Department of Public Works

Preliminary Acceptance Punch List Bent Grass Meadows Drive/Woodmen Frontage Road

7/25/2024

Bent Grass Meadows Drive/Woodmen Frontage Road
Per Approved Plans
7/25/2024

C1.1
Sheet 3 of 8

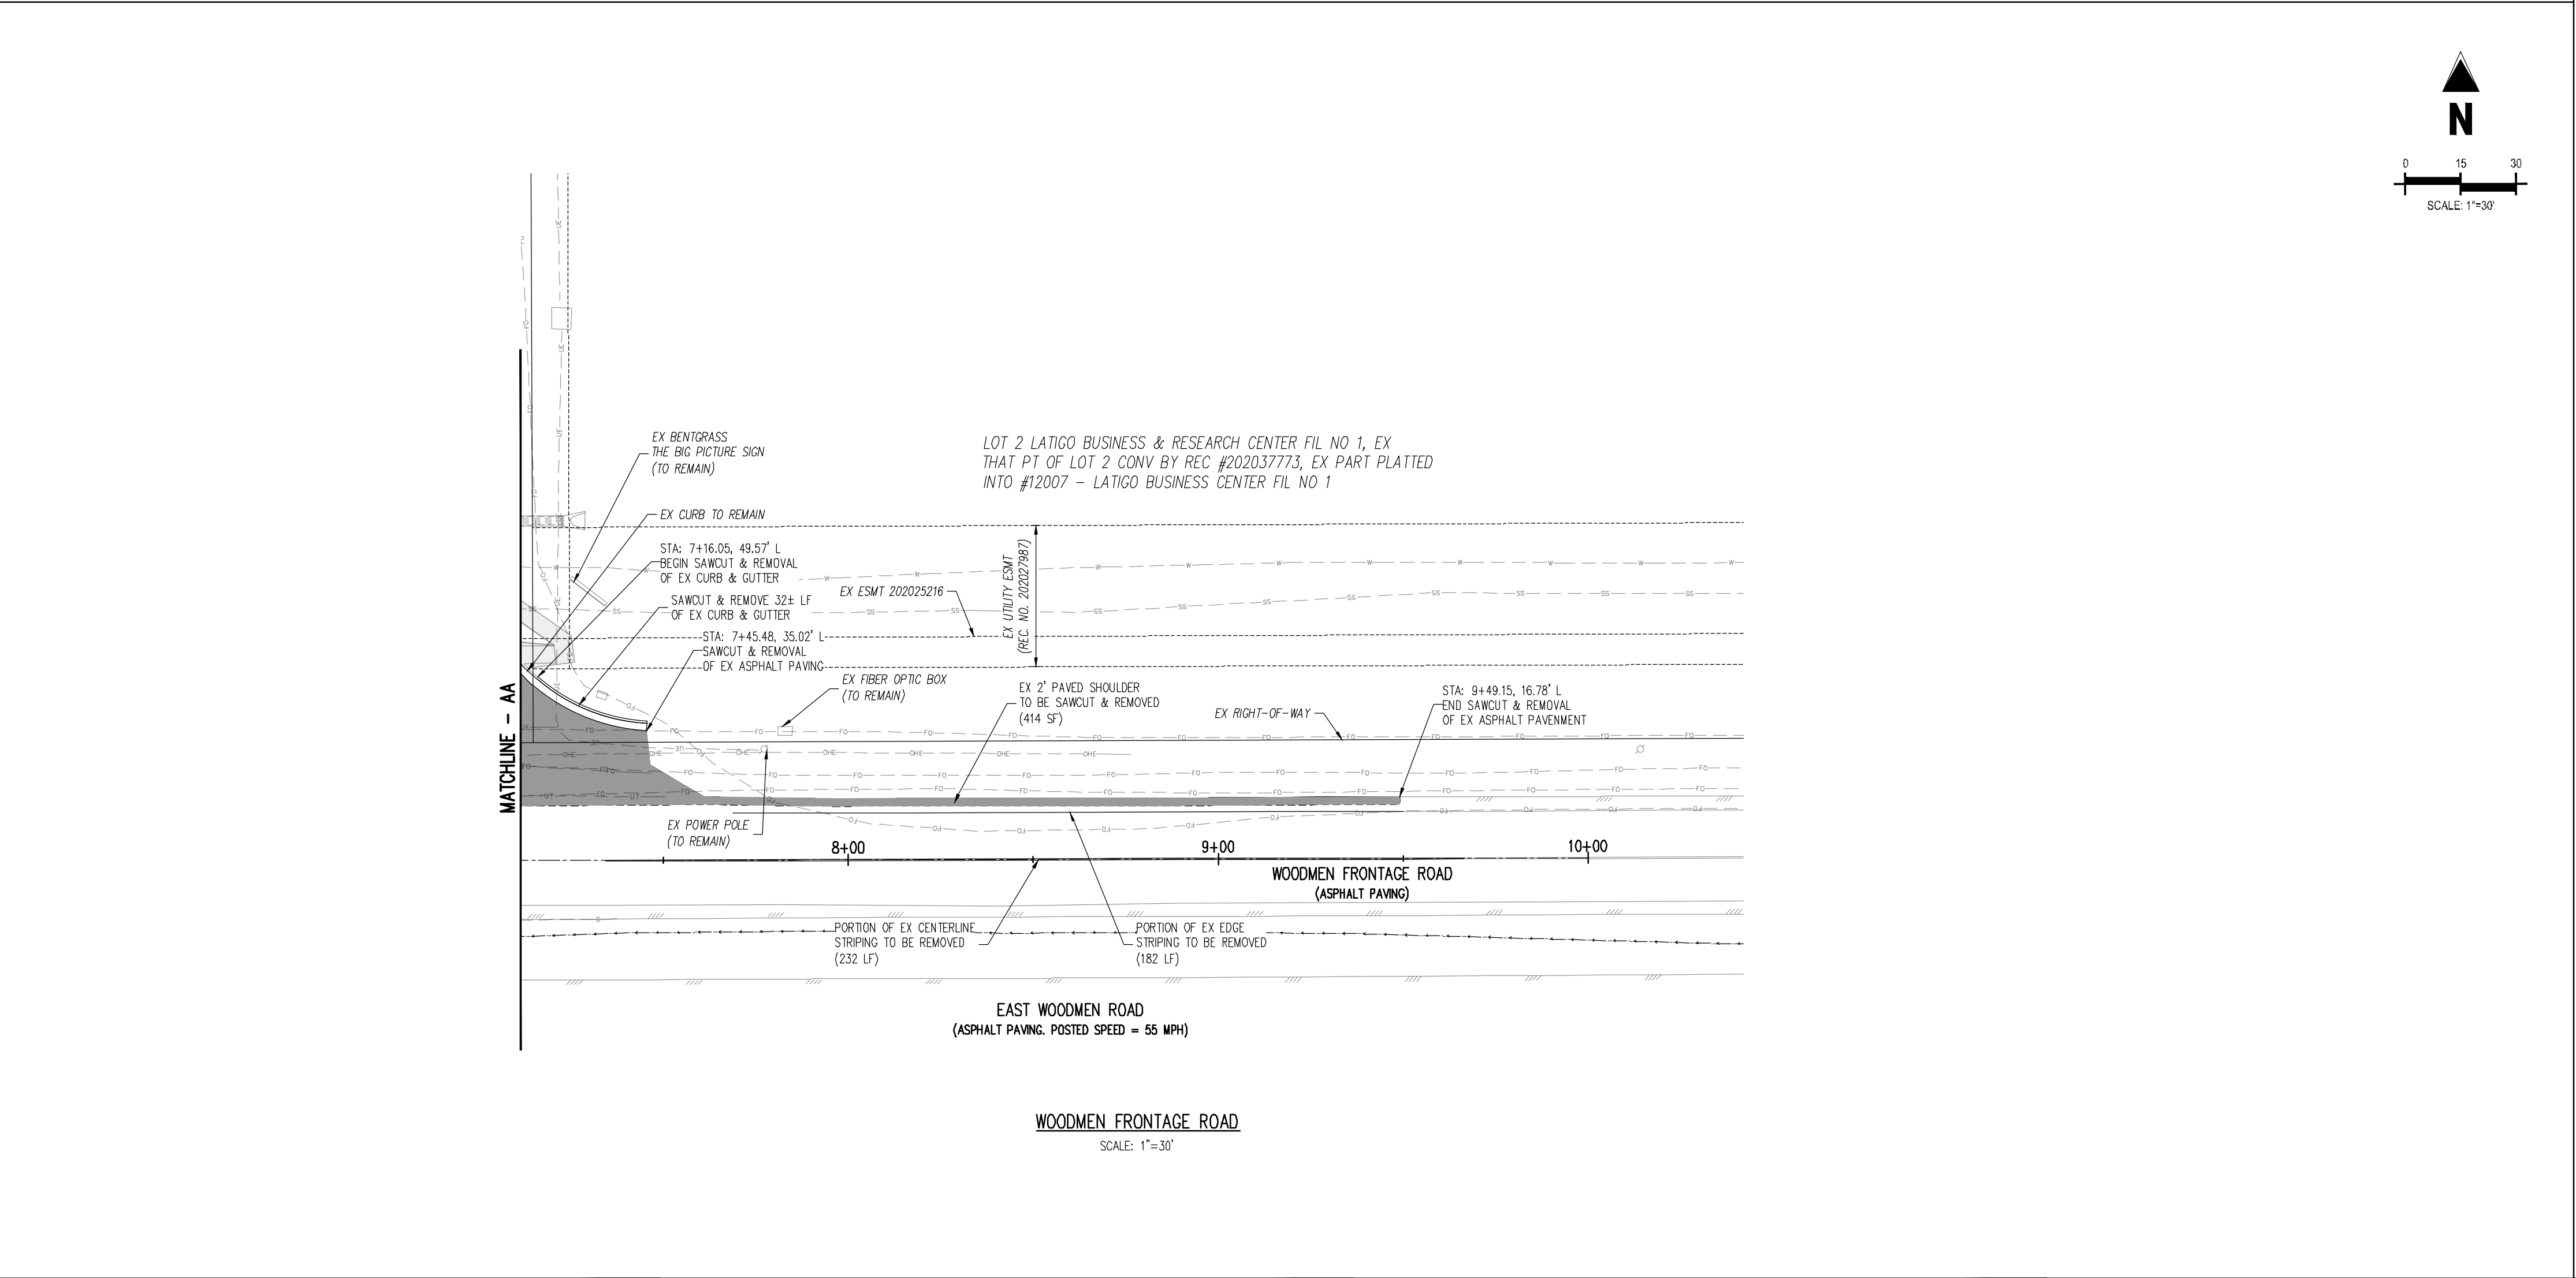
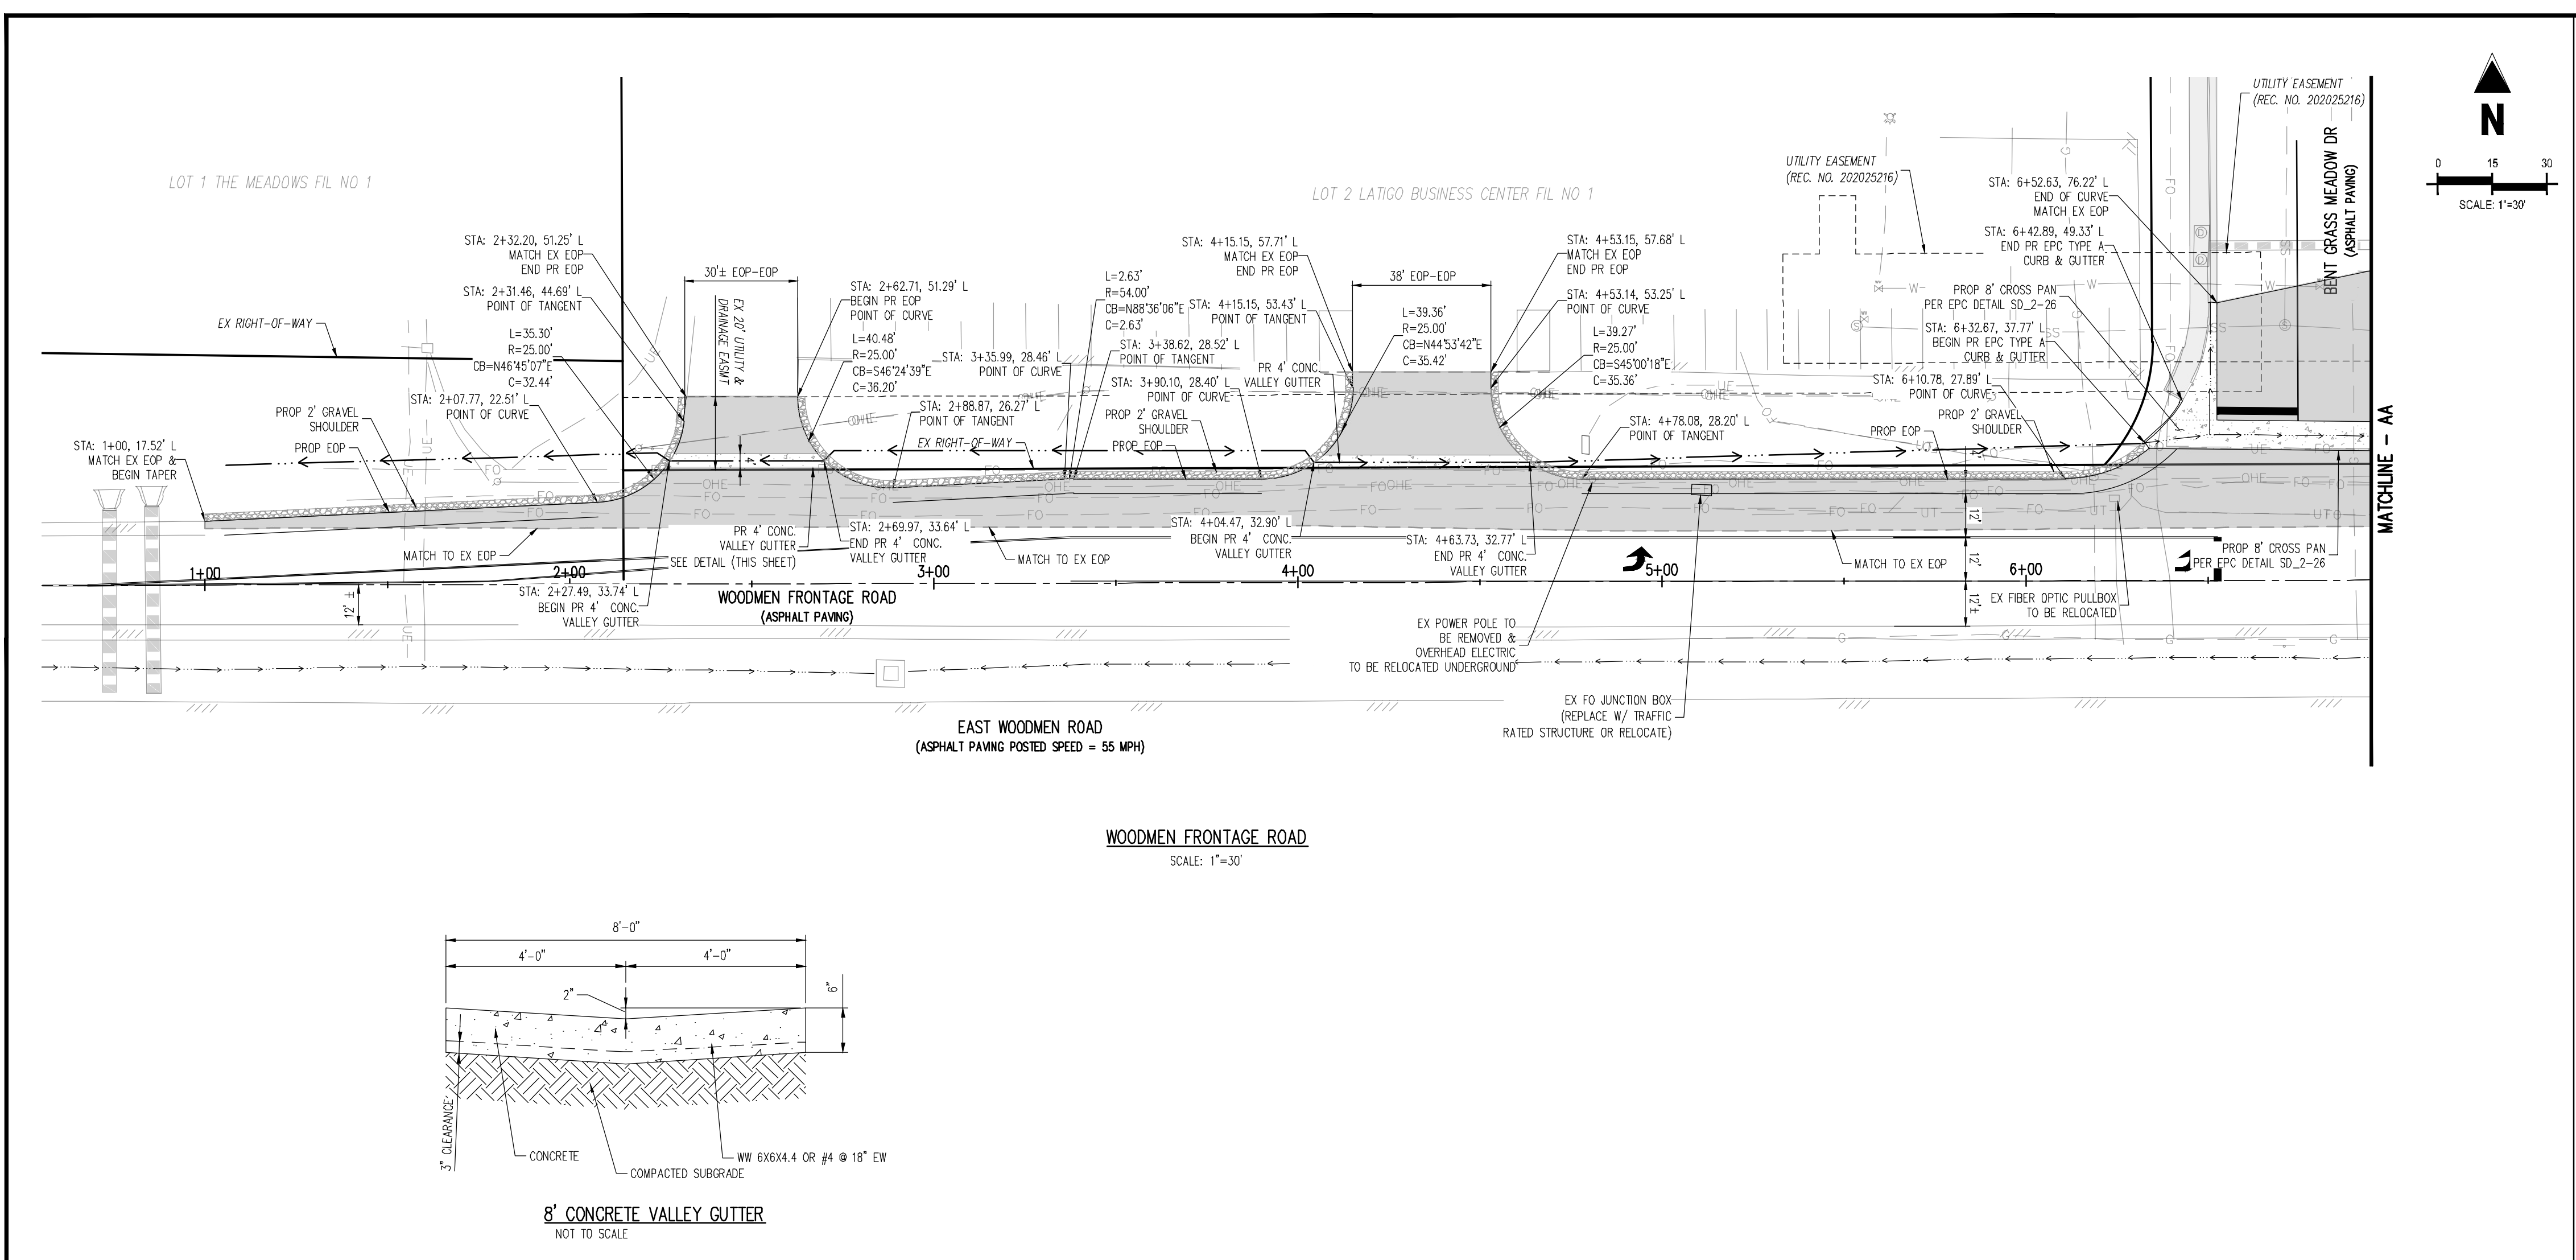
- Cut swale on far west driveway on the west side.
- Clean site (stakes, trash...)
- Relocate stop sign on Bent Grass Meadow Dr and frontage intersection as called out on Construction Drawing C1.1
